PROJECT NAME: **Yellowstone Trails Estates Plat (LP-09-06)**

## KITTITAS COUNTY LAND USE HEARING EXAMINER

<b>IN THE MATTER OF</b>  LP-09-06 Yellowstone Trail Estates Preliminary Plat	) ) ) )	<b>RECOMMENDED FINDINGS OF FACT, CONCLUSIONS OF LAW, DECISION AND CONDITIONS OF APPROVAL</b>
---	------------------	--

## STAFF REPORT YELLOWSTONE TRAIL ESTATES PRELIMINARY PLAT

PLAT OF YELLOWSTONE TRAIL ESTATES
A PTN. OF THE EAST 1/2 OF SECTION 9, T.22N., R.11E., W.M.
KITTITAS COUNTY, WASHINGTON

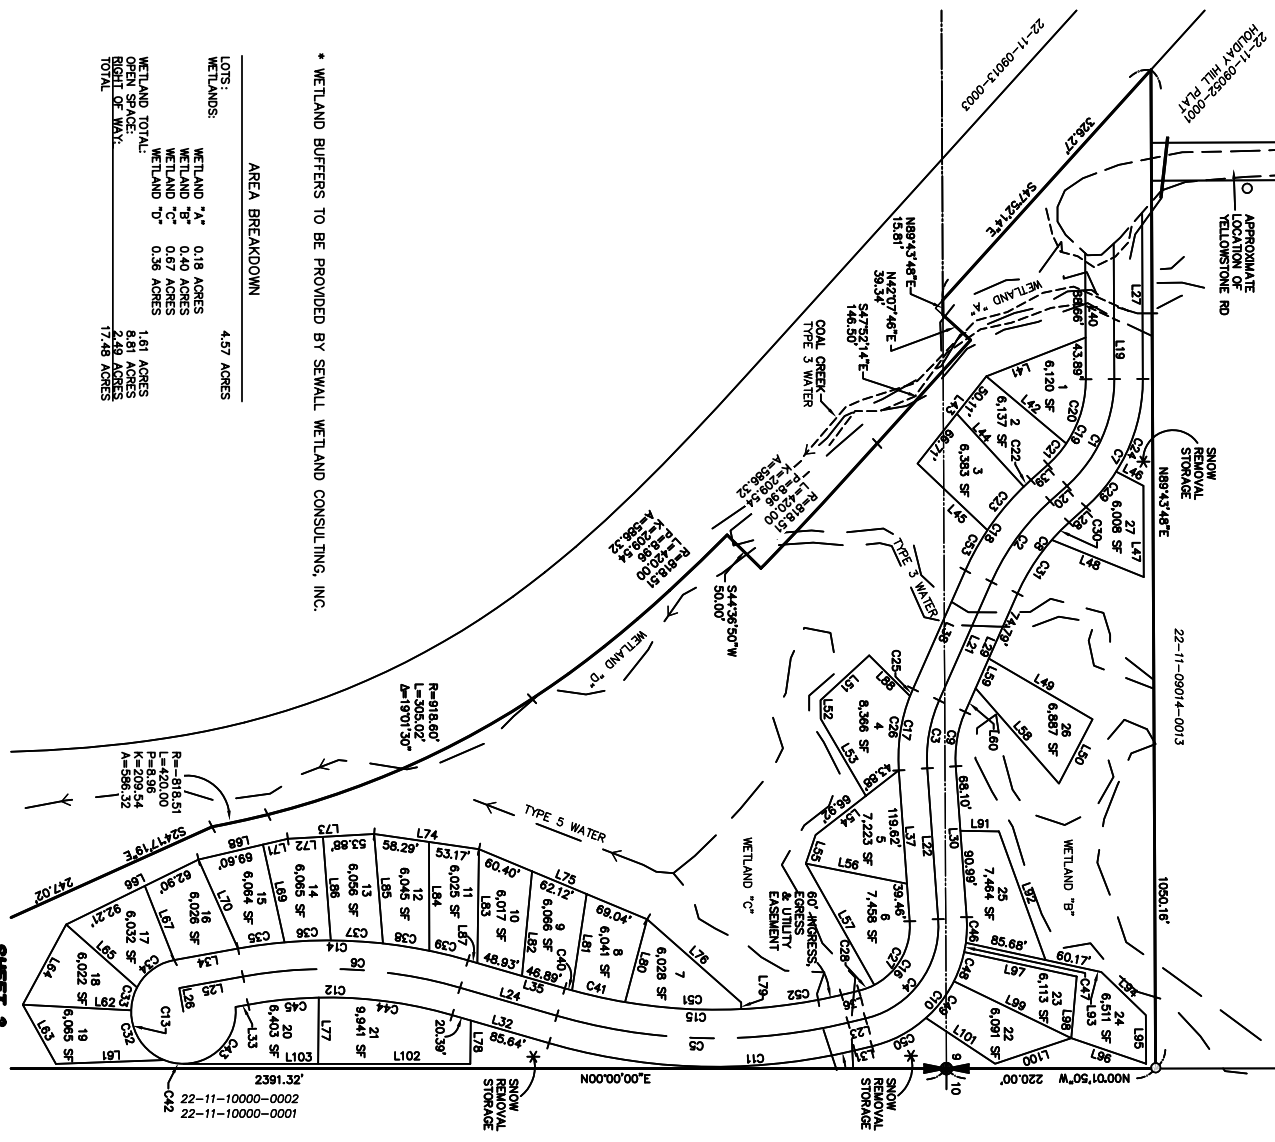
13. Lot 24 Access: Lot 24 is accessed by a 121' long by 10' wide driveway. Based on an average snow accumulation of over 35-feet, a 10' wide driveway of this length will place an excessive burden on the homeowner during snow removal, and may cause issues with the neighbors in Lots 25, 23 and 22. Please see the attached photos which show snowfall on Yellowstone Road. Public Works recommends the lots be adjusted to allow all lots direct access to the private road.

14. Property Line Corrections: Property lines in the northwest corner of the plat shall be drawn to reflect the actual location of Kittitas County right of way and the southernmost portion of the Holiday Hill Plat.

51. The applicant shall work with Kittitas County Community Development Services and Public Works to modify the width of the driveway to Lot 24 in order to permit snow removal without impacting adjacent properties. This may include widening the driveway up to a minimum of 20 feet. Any changes to the width of the driveway to Lot 24 are subject to approval by Kittitas County Department of Community Services and Public Works.
